FIRE RISK MANAGEMENT, INC

Memo Report

Subject: Fire & Life Safety Evaluation of 98 Washington Ave. in Portland, ME

98 WASHINGTON AVE
1st Floor Proposed
(commercial/office/retail)

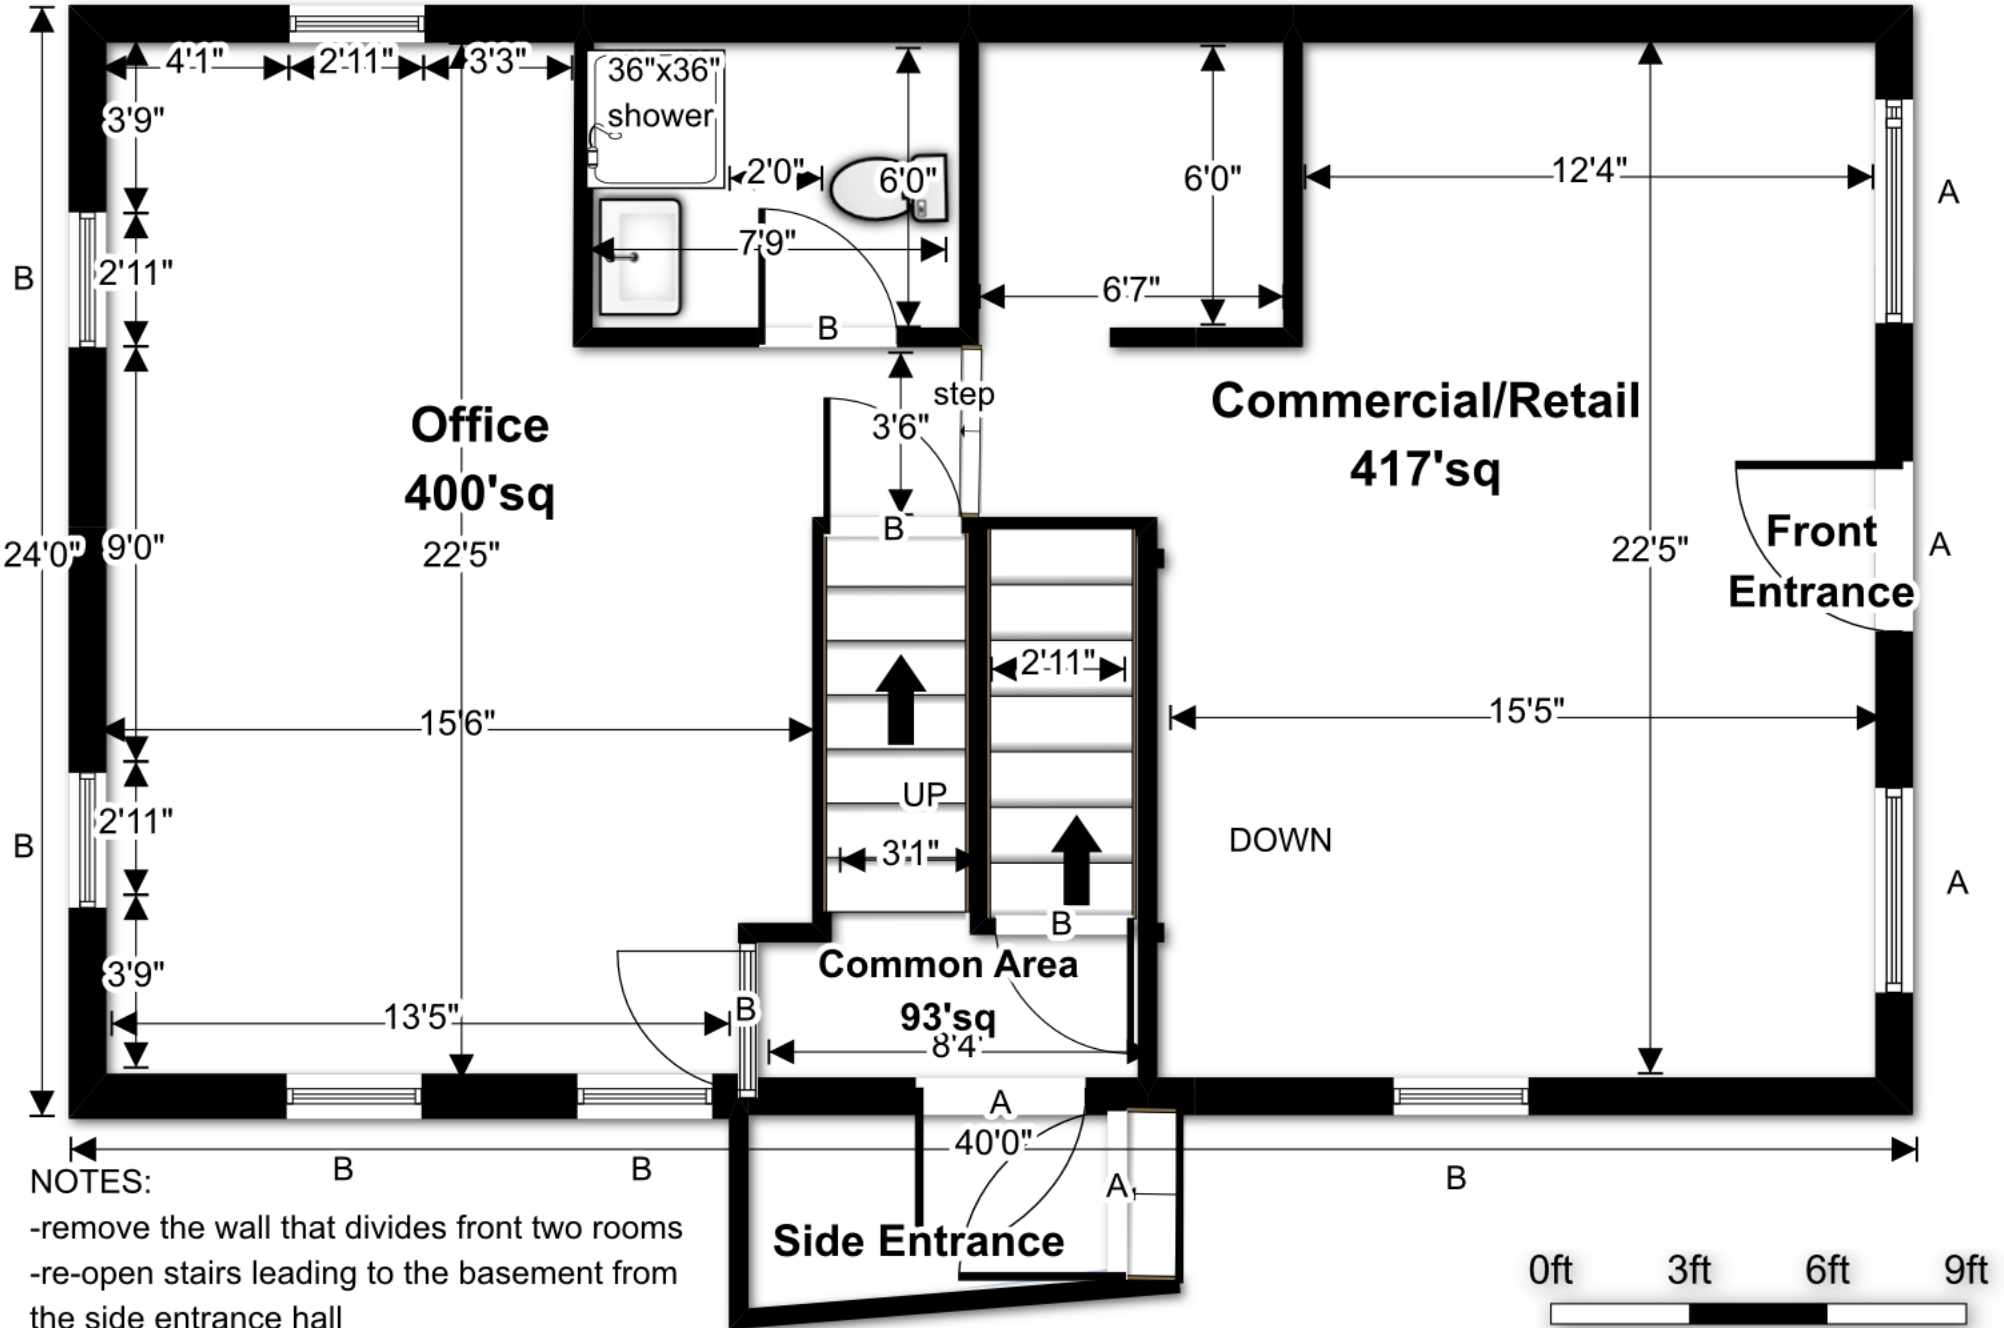
The building is to be provided with two (2) primary exits at the 1st floor level; one on the east side of the building, leading from the proposed Mercantile space, and a second on the south side of the building, which serves as the exit for the enclosed stairway and also serves as the exit from the Business occupancy on the west end of the building. If these exit doors consists of at least a “standard” 36-inch door that provides approximately 34 inches of clear width, they would each have the capacity to accommodate up to at least 170 persons; using the standard exit capacity factor of 0.2 in./person from NFPA 101. Therefore, the building has more than sufficient exit capacity to accommodate the expected maximum occupant load.

The codes typically require that each story and all areas within a building be provided access to at least two means of egress. Although the 1st floor area indicates that the mercantile and business portions of the floor are connected via an open hallway, due to the expected occupant loading of each, and the fact that each has direct access to an exterior exit door, a single exit would be allowed for each of these areas and if desired, they could be separated from one another.

To comply with the NFPA 101 requirements it will also be necessary to have an installed fire alarm/notification system throughout the building. It is understood that the desire is to utilize the existing fire alarm/notification system going forward, but it will be necessary to verify that the existing system can support the alarm/notification requirements of the current codes. In general, since the sprinkler system is required to be supervised and if its operation is used to initiate the building's fire alarm system, it would not be required to have installed manual pull stations anywhere in the building; with the one exception being the Mercantile space. NFPA 101, Chapter 36, still includes a requirement that at least one manual pull station be provided, even when a sprinkler system is installed. In this instance, the pull station that is located by the main entrance/exit door for this space would need to remain.

SEPARATION AND STC DETAIL  
98 WASHINGTON AVE

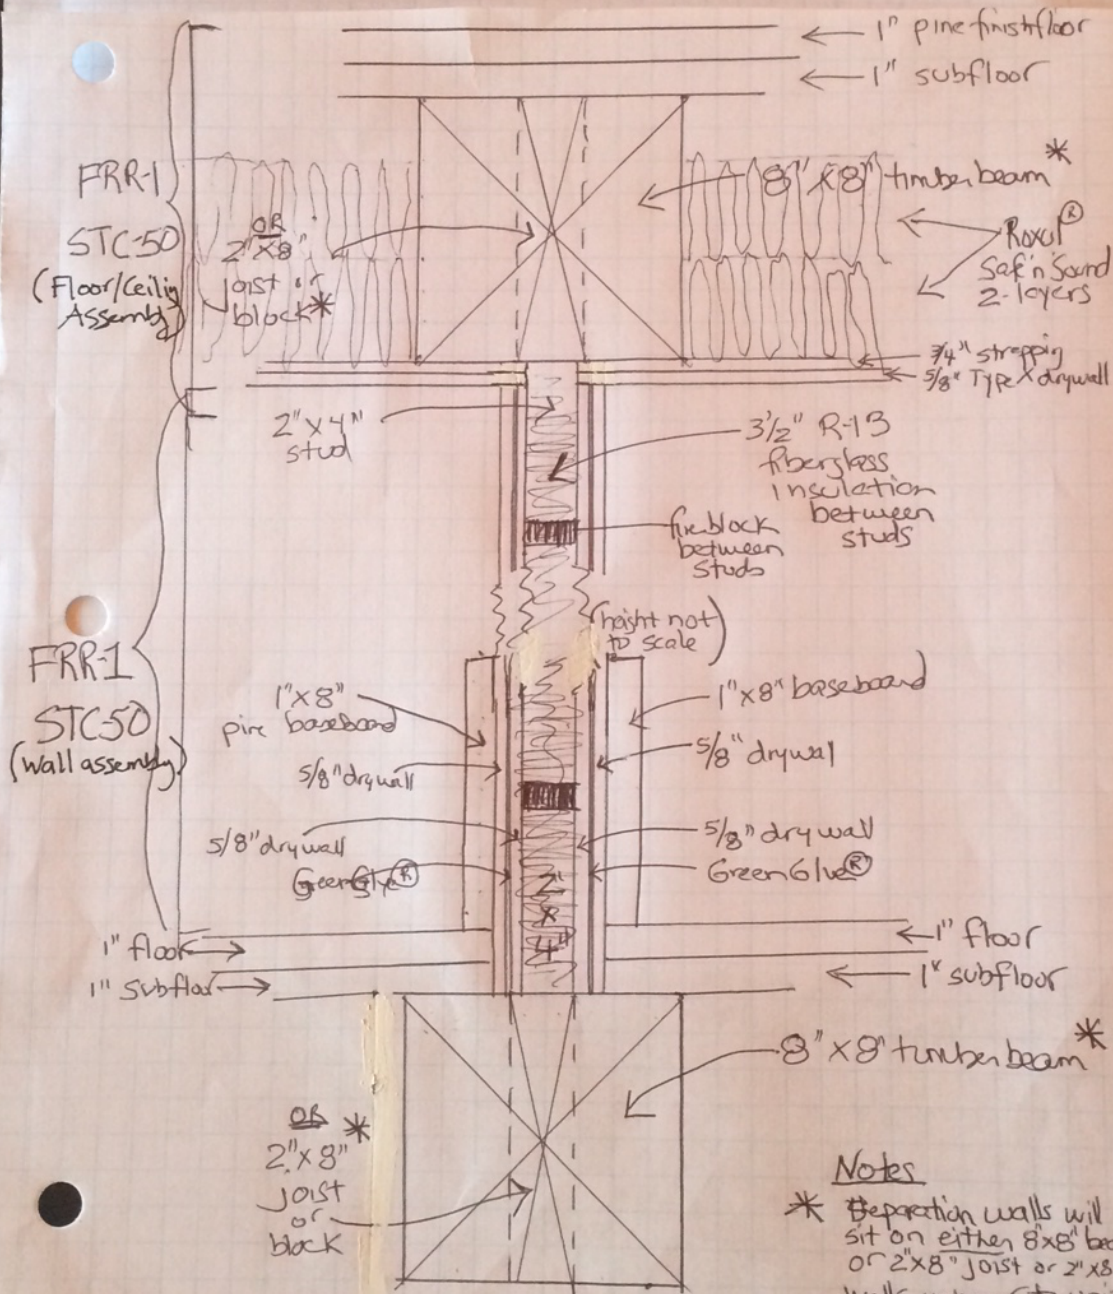
- c. ½-hour FRR for all walls and floor/ceiling assemblies separating individual dwelling units. Use of standard wall and floor/ceiling construction materials should be adequate; albeit all penetrations in these barriers must be properly protected/sealed.
